## WEST SUSSEX COUNTY COUNCIL CONSULTATION

| <b>FROM:</b>                    | WSCC - Highways Authority                                                                                                                                                                                                                                                                                                                                                                               |
| <b>DATE:</b>                    | 16 July 2021                                                                                                                                                                                                                                                                                                                                                                                            |
| <b>SUBJECT:</b>                 | A/110/21/PL<br><br>Erection of retirement apartment with 20 No. 1 Bed flats & 13 No.2 Bed flats with communal facilities & car parking, erection of a retail store with car parking & associated highway works. This application affects the character & appearance

PRELIMINARY SITE ACCESS ARRANGEMENTS

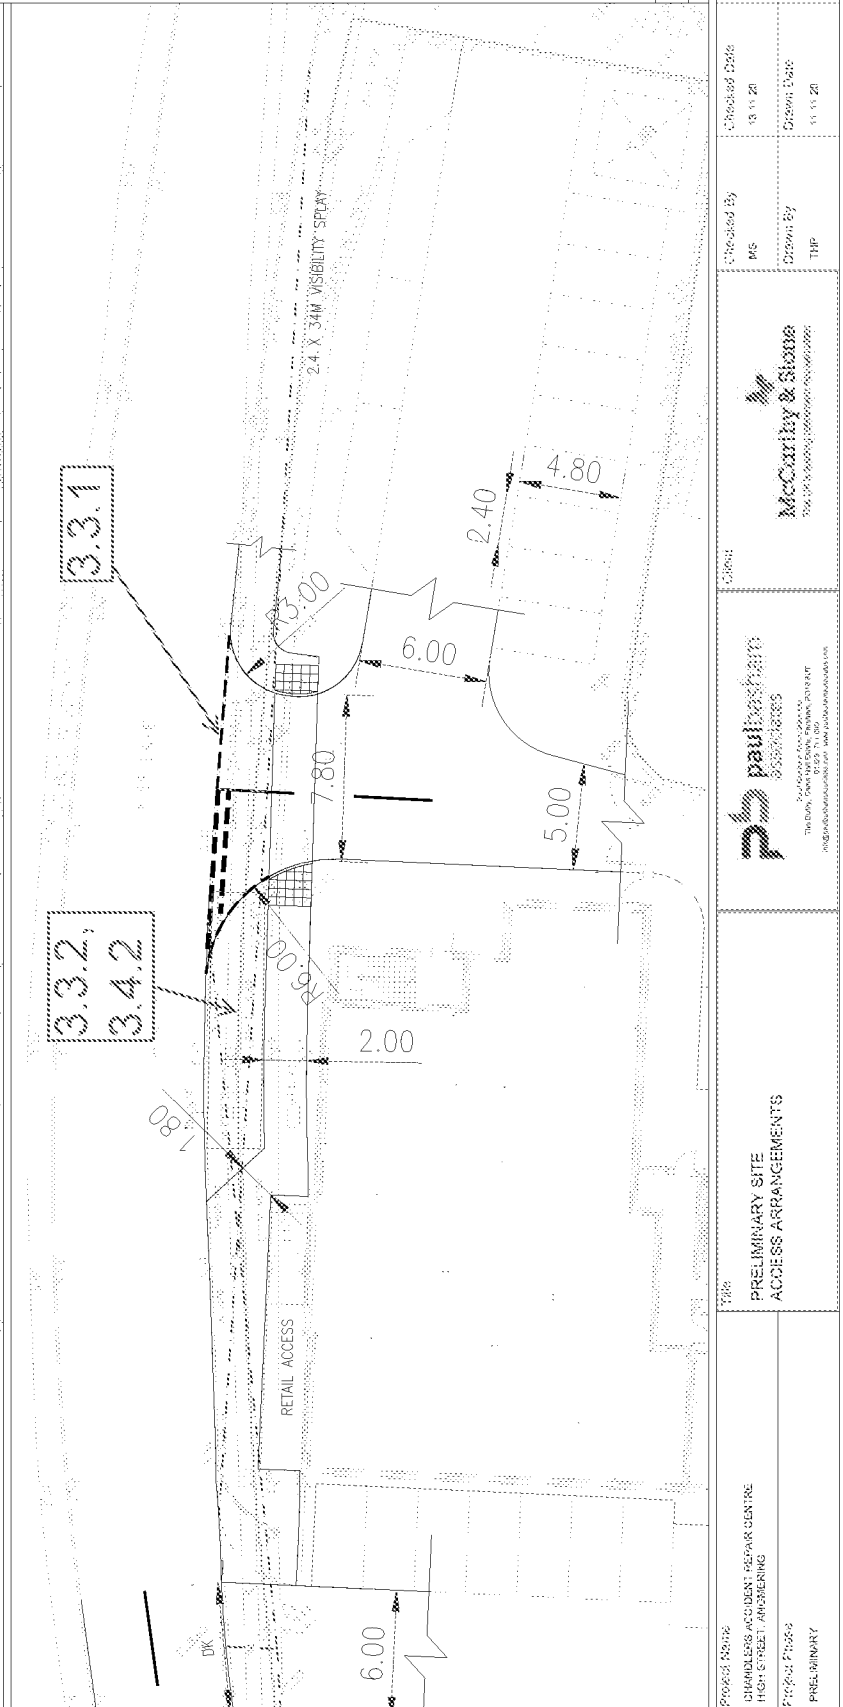
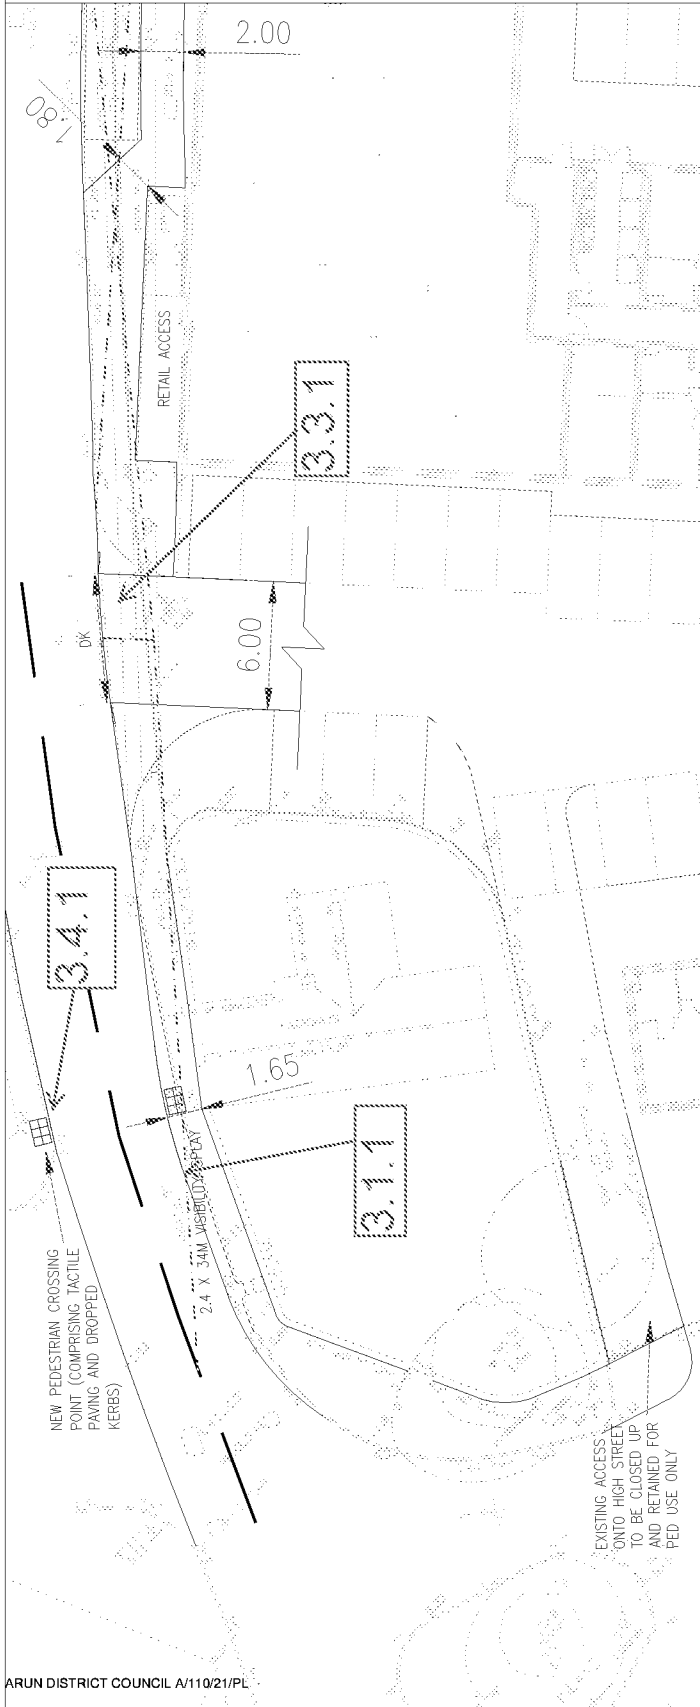
Drawing no: 034.0135.001 demonstrates the site with split access. One for the residential element which will be a formalisation of the existing access to the west, to form a cross over style access with an internal access road serving the car parking area. This is wide enough to allow the passing of two vehicles so traffic on the highway can remain free flowing.

Access to the convenience store to the east will also cater for access to a small proportion of parking spaces related to the residential side of the development, which will be segregated via a gate from the store parking area.

Additional tactile paving and dropped kerbs will be provided at the bell mouth access on Water Lane to improve pedestrian connectivity and safety.

Under section 3.6 it is proposed that the footway will be widened to approx. 1.8m west of the site and a minimum of 1.65m within the vicinity of Eachways to the west, with this being achieved by narrowing the carriageway. The TS states this has been agreed with the LHA. Having checked through the pre application submission and our response this has not been agreed or been favourably looked upon as stated. This section of Water Lane already has a pinch point in the vicinity of Eachways. Whilst the footway narrows in this location it is only for a couple of meters before it opens back up again to a similar width of the footways in the local area. As well, site pedestrian access is being provided directly onto High Street, via the old vehicle access being closed off to vehicles but left as pedestrian only access. The LHA do not consider that a further narrowing of the carriageway outside Eachways would be appropriate given the level/type of traffic that is carried on Water Lane and the fact that pedestrian access is also being provided into /through the site via High Street.

Project Name	CHANDLER'S ACCIDENT REPAIR CENTRE HIGH STREET / ANDOVERING	Title	DELIVERY AND SERVICING BAY ARRANGEMENTS	Client	Paul Basham 034 0135 003	Project Drawing No	034 0135 003	Revision	A
Project Phase	PRELIMINARY	Drawn Date	11.11.20	Drawn By	TJP

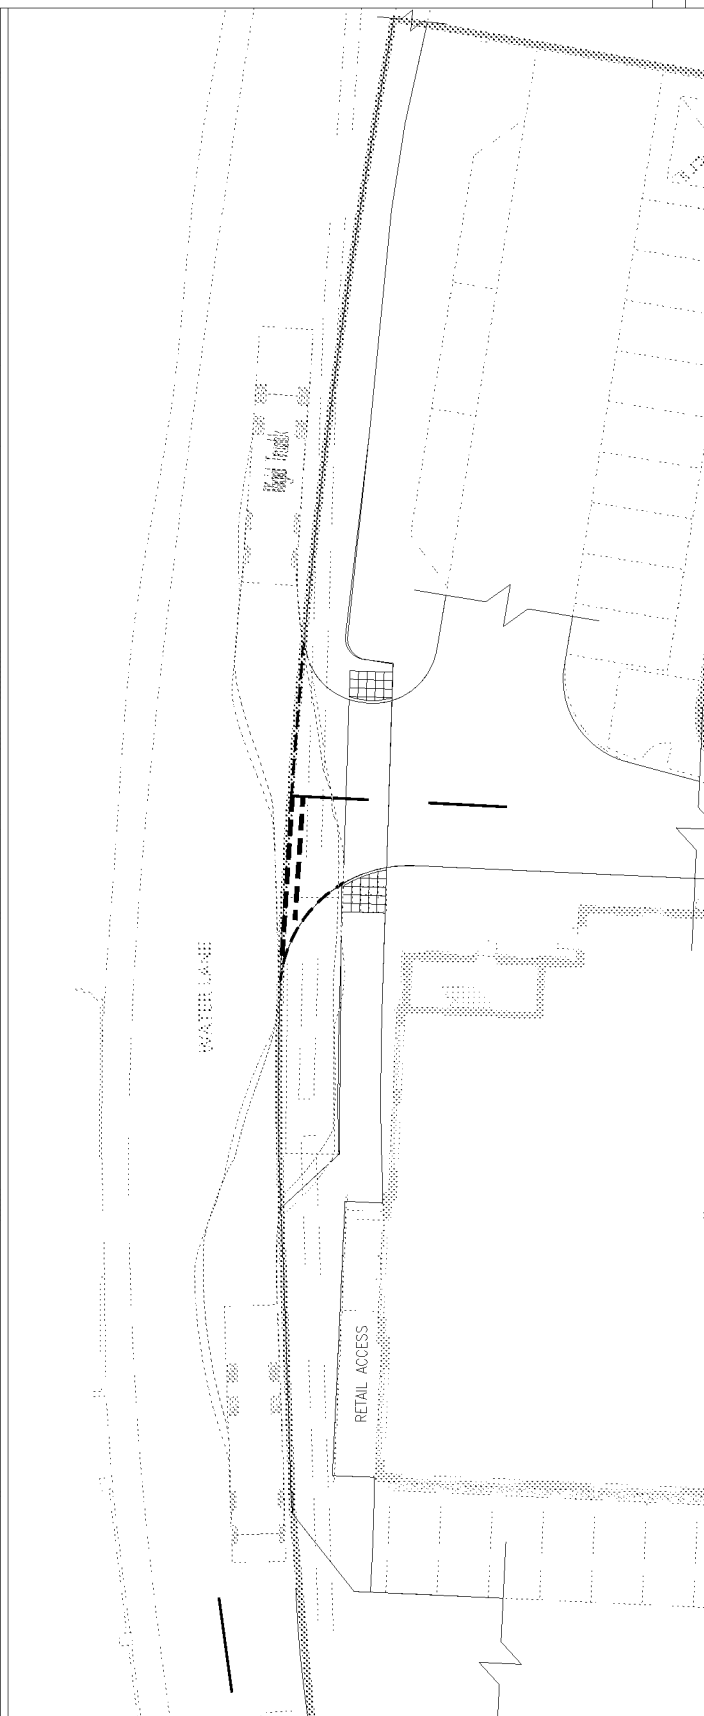
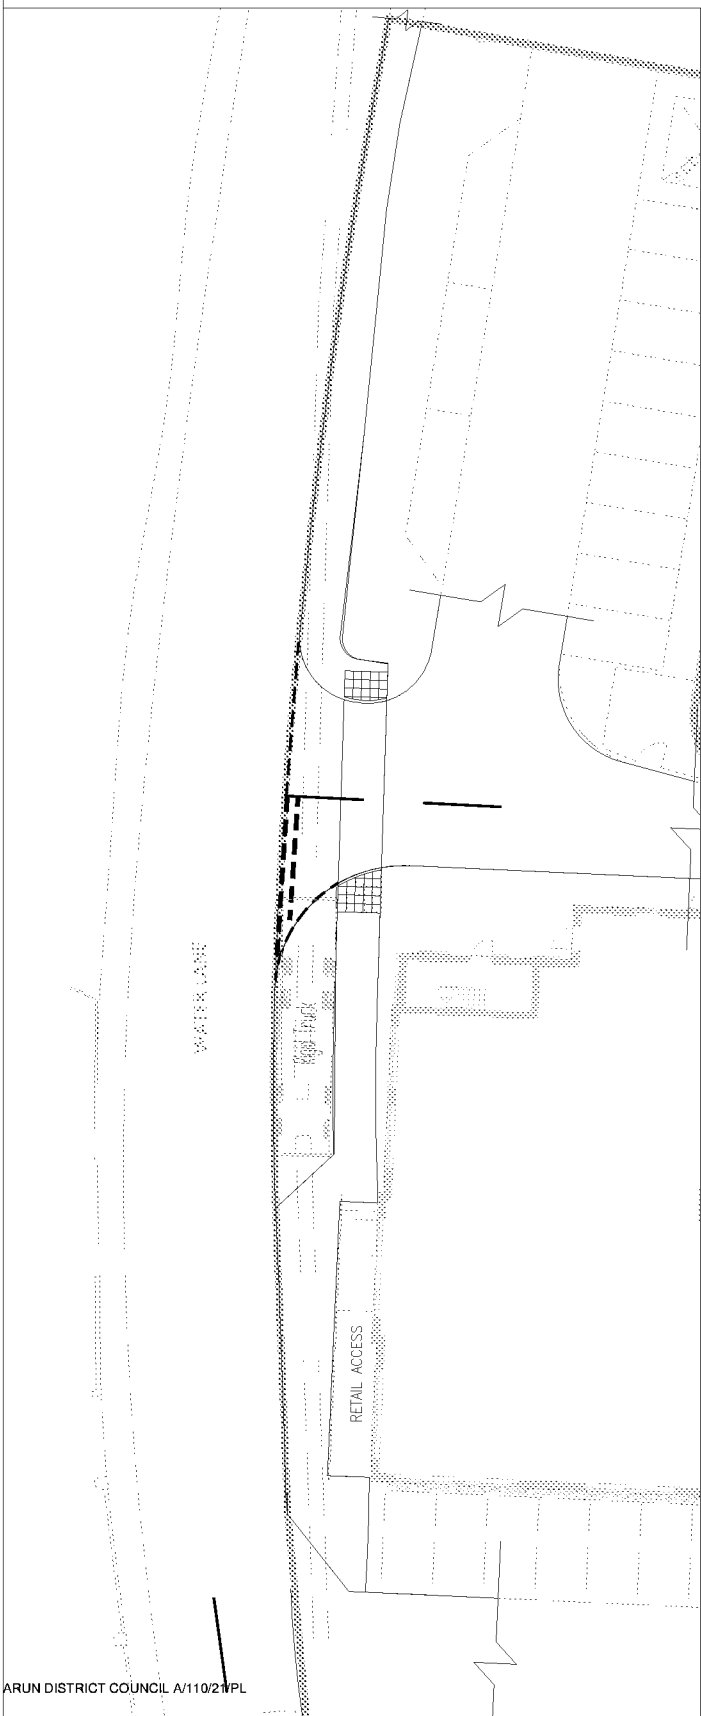
- Problem 3.3.1 – Movement of larger vehicles at access onto Water Lane – The LHA are in agreement that the vehicle tracking provided demonstrates that the bell mouth access to the convenience store and the refuse collection store for the retirement flats is able to support the once a week infrequent movement of a refuse vehicle, given the low speed environment and the context of Water Lane it is not expected that the occasional small over running of the centre line will lead to a safety concern.
